**REQUEST**

Current Zoning: B-1(CD) (general business, conditional)  
Proposed Zoning: O-1(CD) (office, conditional)

Approximately 1.04 acres located at the northwest intersection of Carmel Road and Little Avenue, north of Pineville-Matthews Road, and east of Johnston Road.

**SUMMARY OF PETITION**

Conceptual Rezoning Plan

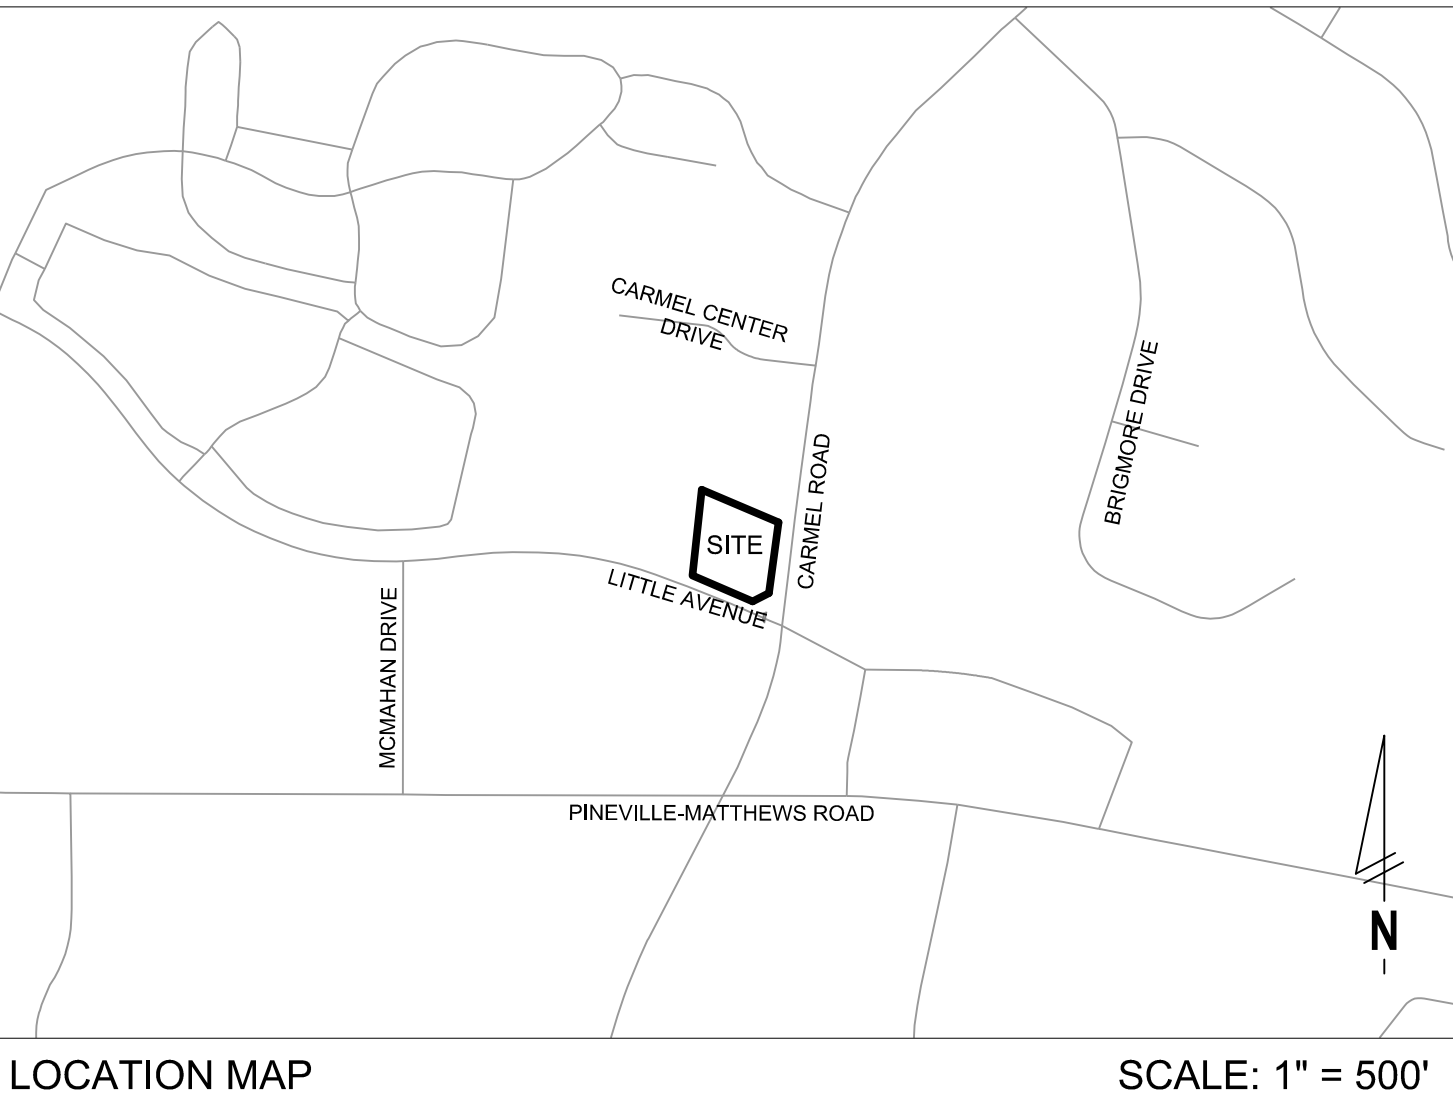
1. Incorporate architectural design standards as provided by Urban Design staff. **Addressed**
  - o ~~Facades fronting streets shall include a combination of windows and operable doors for a minimum of 60% of each frontage elevation transparent glass between 2' and 10' on the first floor. Up to 20% of this requirement may be comprised of display windows. These display windows must maintain a minimum of 3'-0" clear depth between window and rear wall. Windows within this zone shall not be screened by film, decals, and other opaque material, glazing finishes or window treatments. The maximum sill height for required transparency shall not exceed 4'-0" above adjacent street sidewalk.~~

- o ~~Multi-story buildings should have a minimum of 20% transparency on all upper stories.~~
2. Clarify if parking will be present under the building below grade or podium. If podium, the building should present ground floor active use along the public street fronts. **Addressed**

3. Add a note that no parking and maneuvering will be located between the building and street. **Addressed**

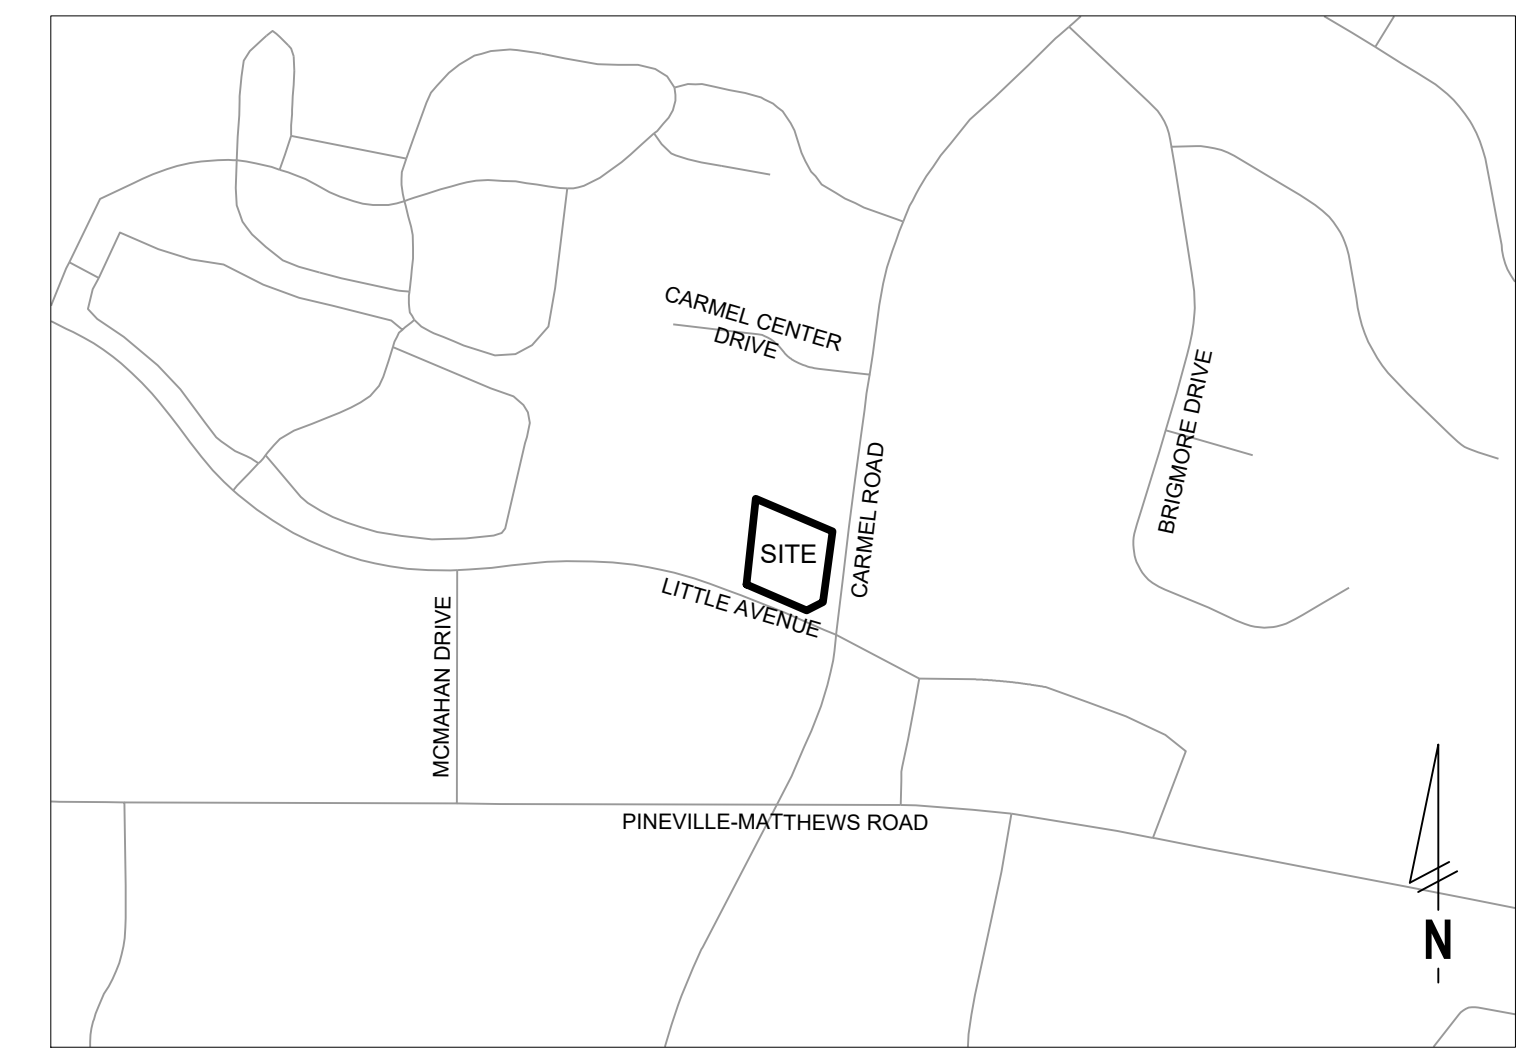
4. Adjust the site plan to show the back of curb and gutter along Carmel Rd at 33ft from the centerline to accommodate the Charlotte Streets Map with a roadway typical section of CLDSM 11.09 Major Thoroughfare. (Site plan currently shows 32 ft from centerline.) **Addressed**

5. Remove layers showing existing development or move the existing development information to a separate sheet. **Addressed**
6. Label and dimension the 12 ft multi-use path and 8 ft planting strip shown along Carmel Rd. and label and dimension the existing planting strip and sidewalk along Little Ave. **Addressed**
7. Add a note committing to the construction of the 8 ft planting strip and 12 ft multiuse path. **Addressed**
8. Add a note committing to the provision of the 14 ft Class C buffer that is shown on the site plan. **Addressed**

9. Label and dimension the curb and gutter from the centerline of each road on the site plan. **Addressed**
